Our Case Number: ACP-323849-25

Re: The proposed development is for a mixed use development that seeks the regeneration and adaptive reuse of a strategic brownfield site, as part of the Limerick City and County Council 'World Class Waterfront revitalisation and transformation project' 'Cleeves Riverside Quarter' in the townland of Farranshone More in Limerick City.

Re: Proposed Development - Cleeves Riverside Quarter / Riverside Campus

Observation / Objection

drawing Shipyard & NCR Boundary Elevations - Proposed

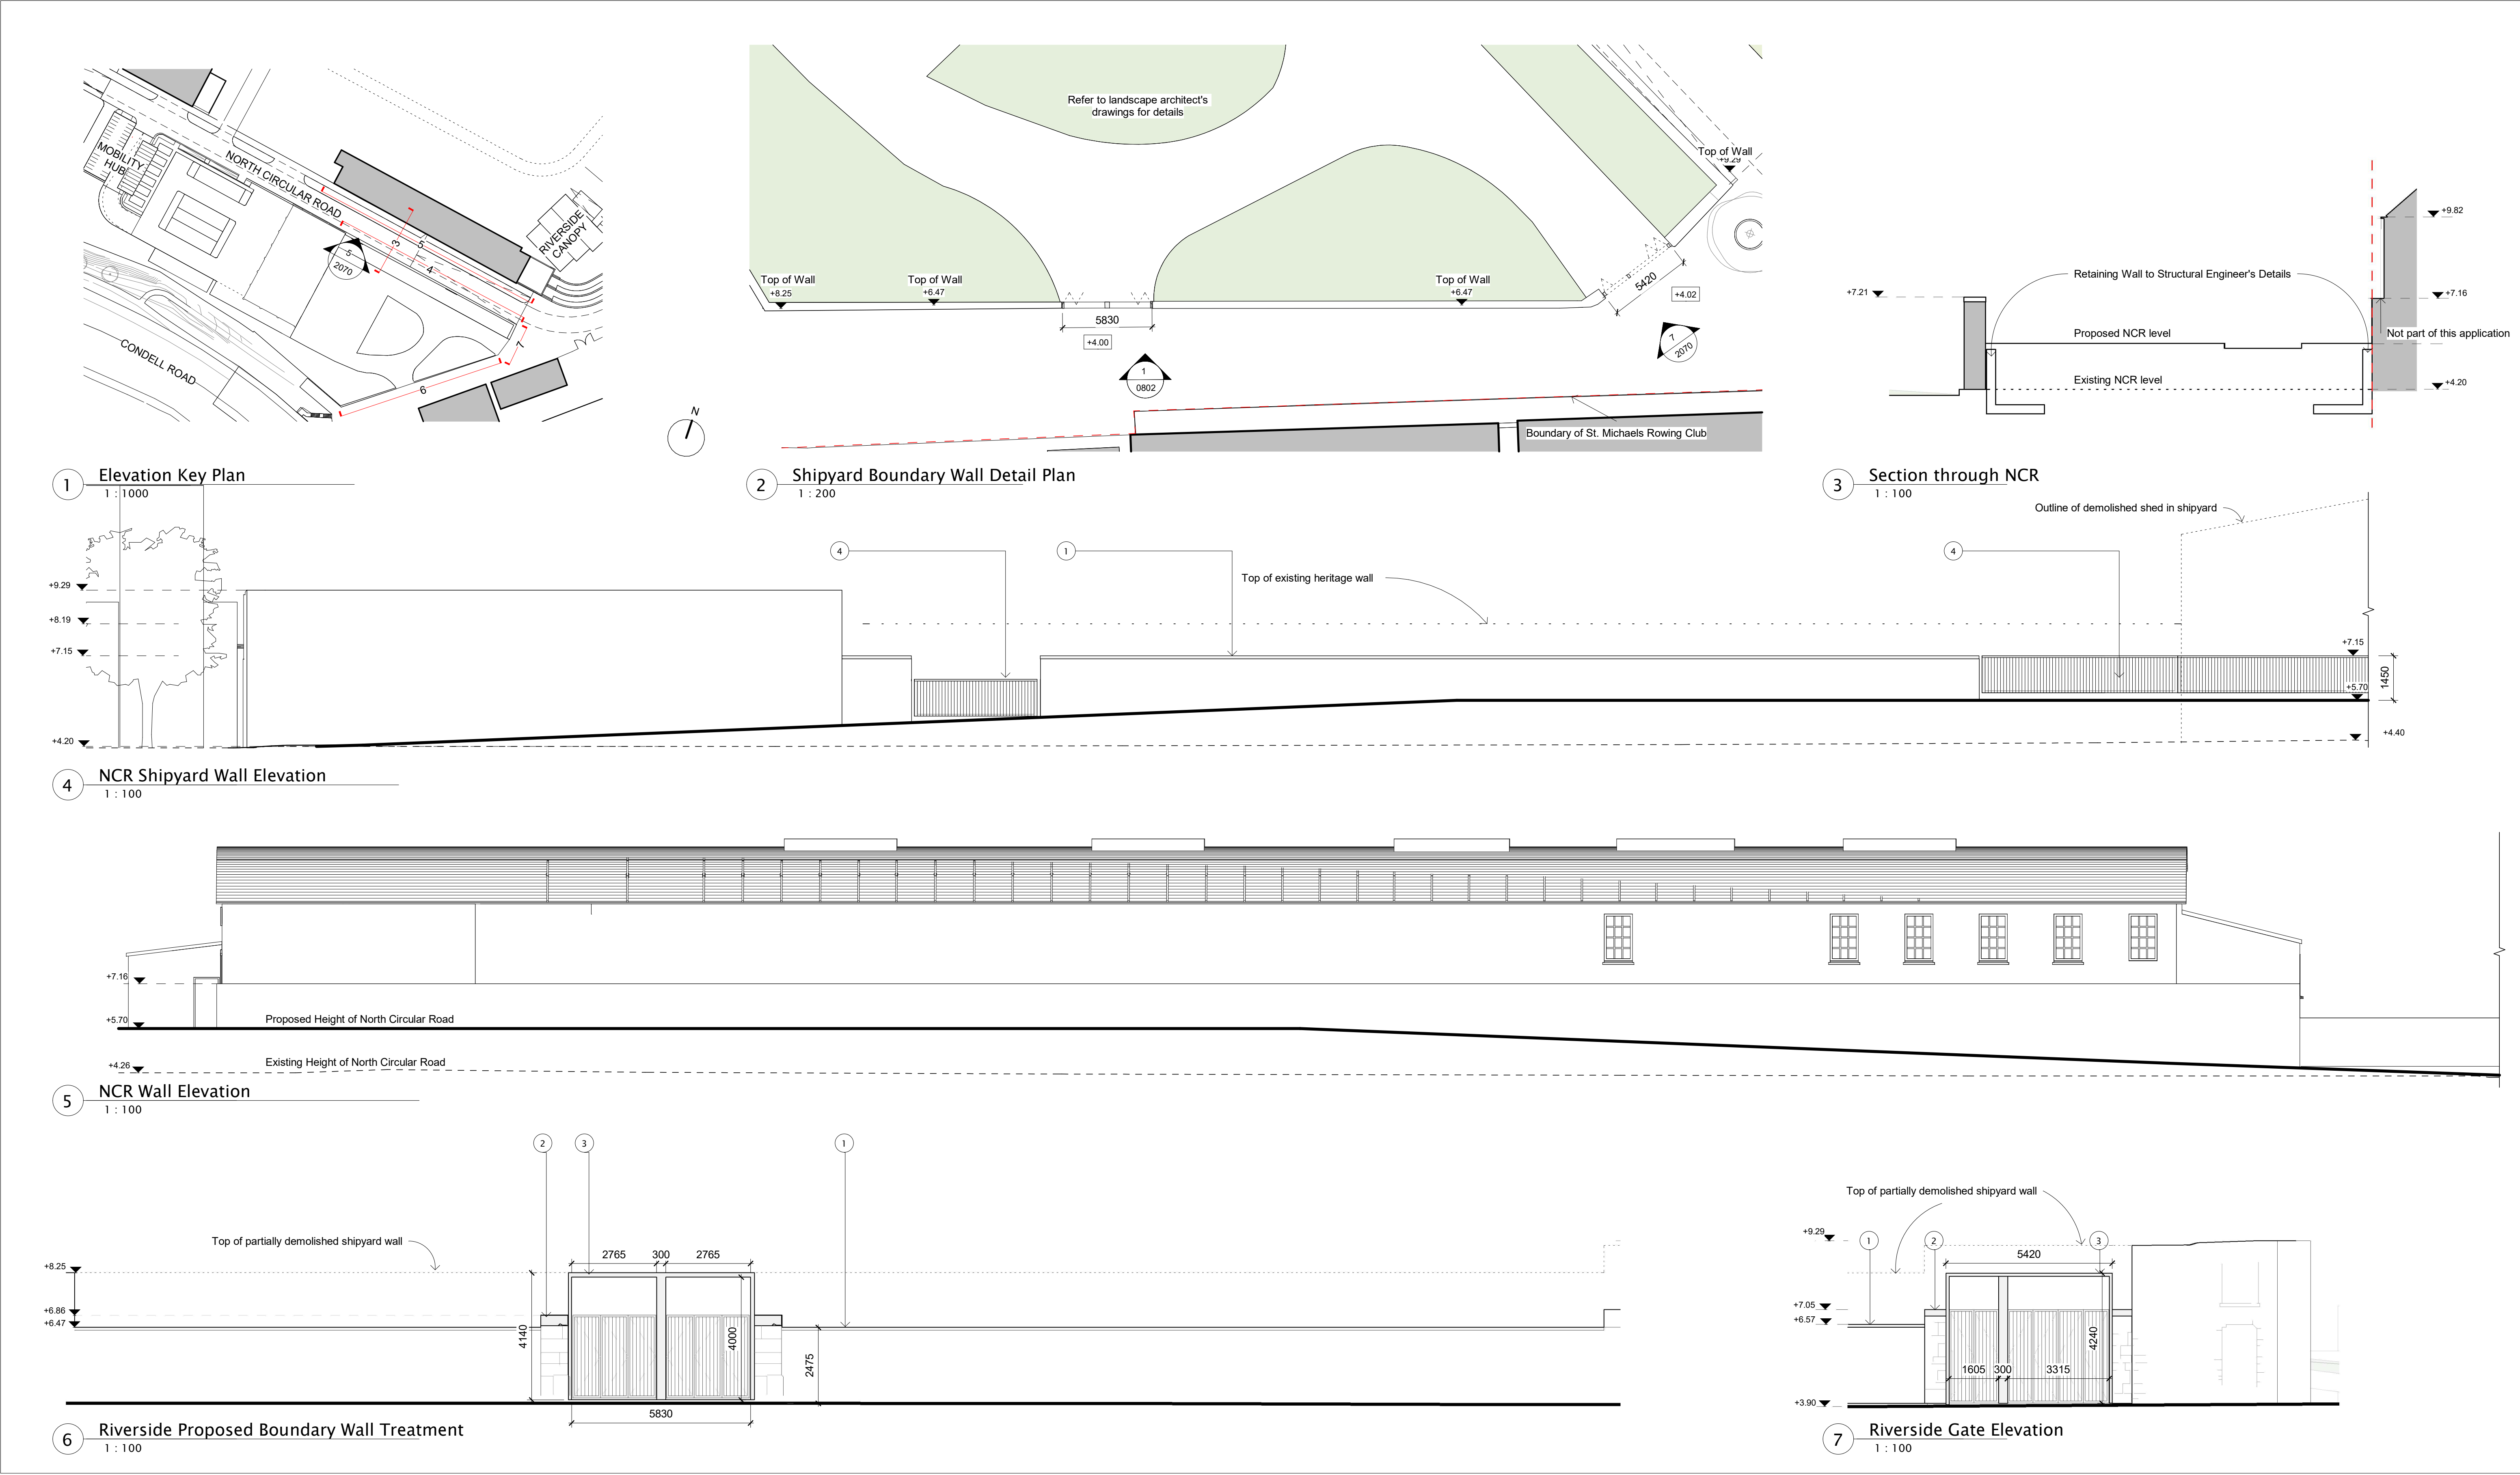
Particularly objectionable is the proposal to provide an entrance/ exit point by making a passageway in the boundary wall halfway up Stone Town Terrace and allowing access from new development, further exacerbating congestion and safety issues. It seems contrary to all good and honest planning to put forward a plan which does not account for these clear, foreseeable, and substantial problems.

Furthermore, this wall was until recently classified as 'protected'/ 'of special interest'; its partial demolition would be in opposition to the protection of heritage and to the character of the street and development site.
